Our Ref: BR/305/19/A

**Town & Country Planning (Control of Advertisement) (England) Regulations 2007 (as amended)
Application for Consent to Display an Advertisement(s)**

Development 1no. internally illuminated fascia sign & 1no. internally illuminated projecting sign.
Location 9-11 Water Tower Buildings London Road Bognor Regis

Site Location & Block Plans
Drg No:
EWM070/SP01

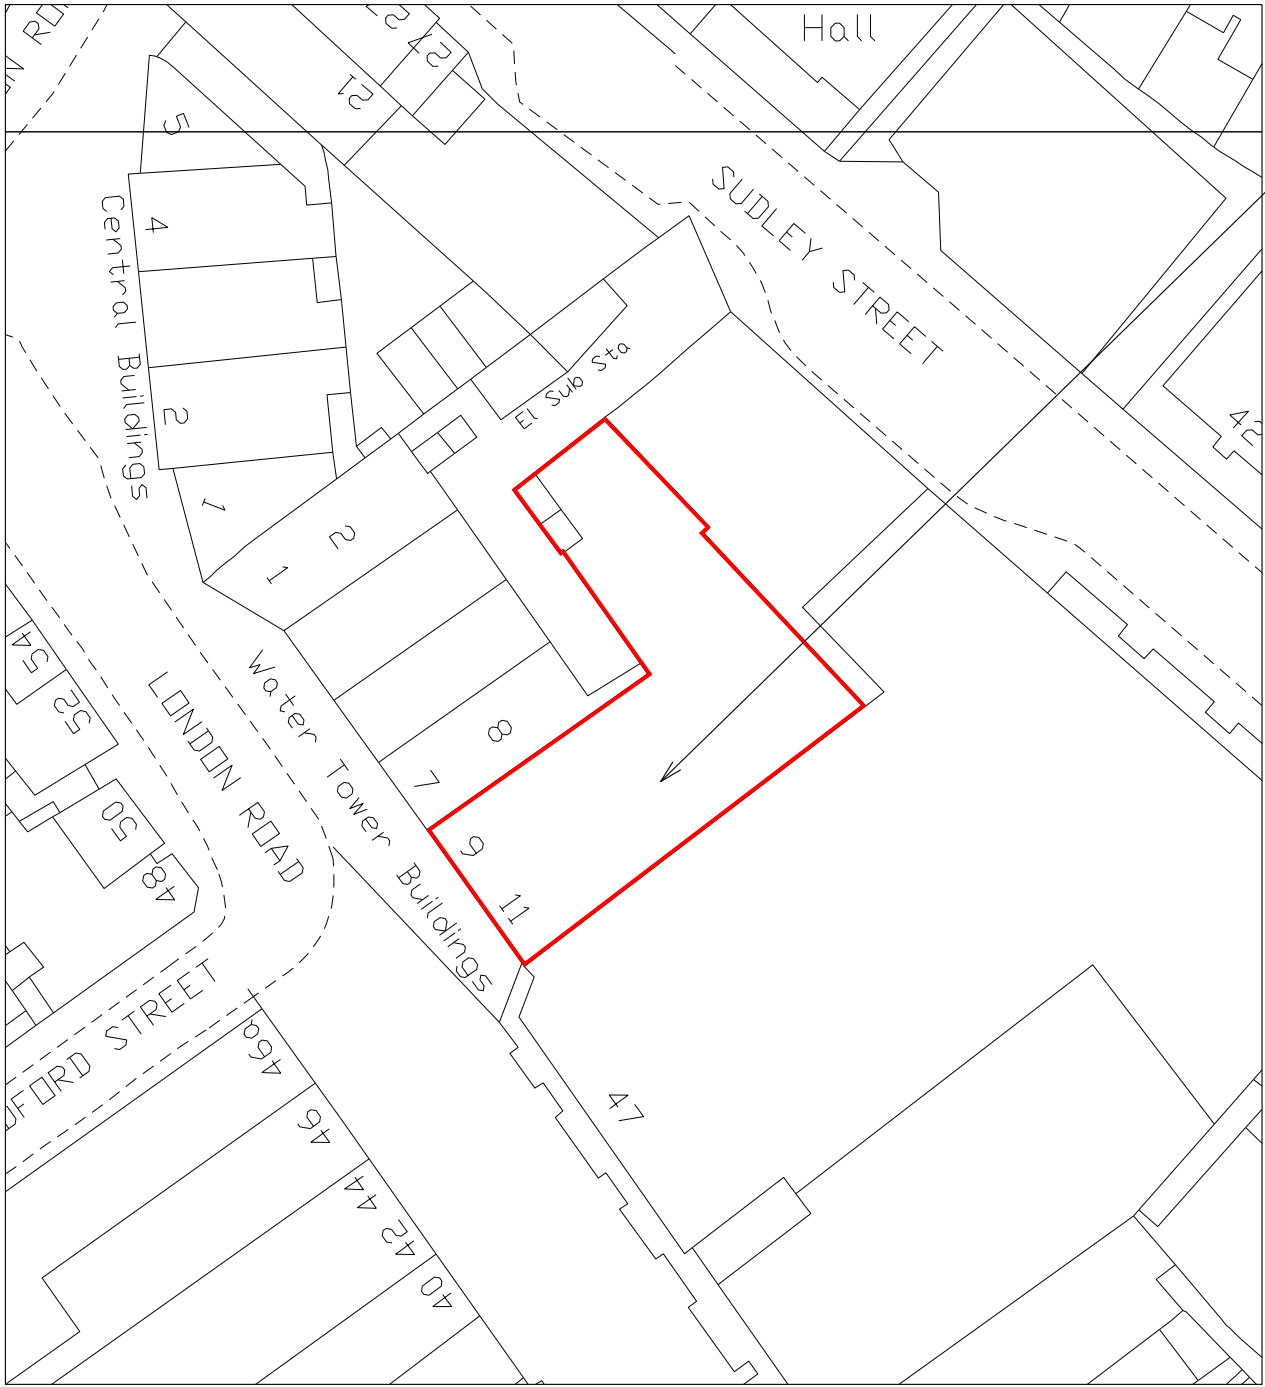
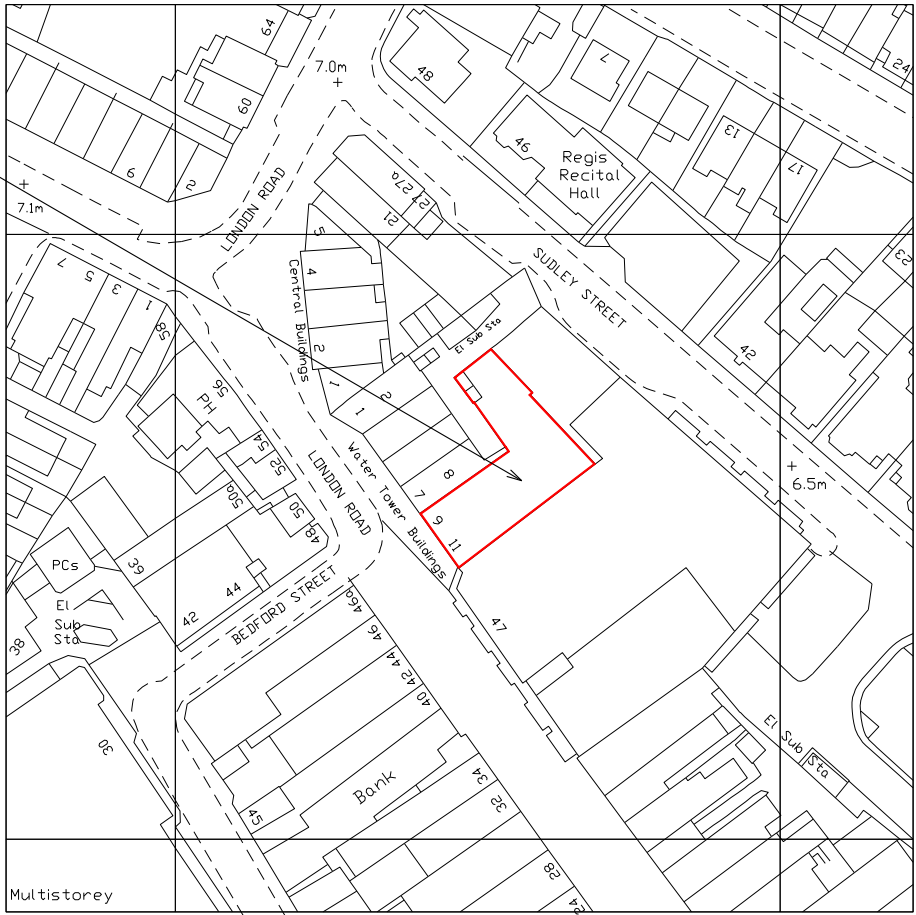
Block Plan

Please submit 1 electronic or 3 paper copies of an amended block/site plan at a scale of 1:500 or 1:200 showing position of proposed signage.
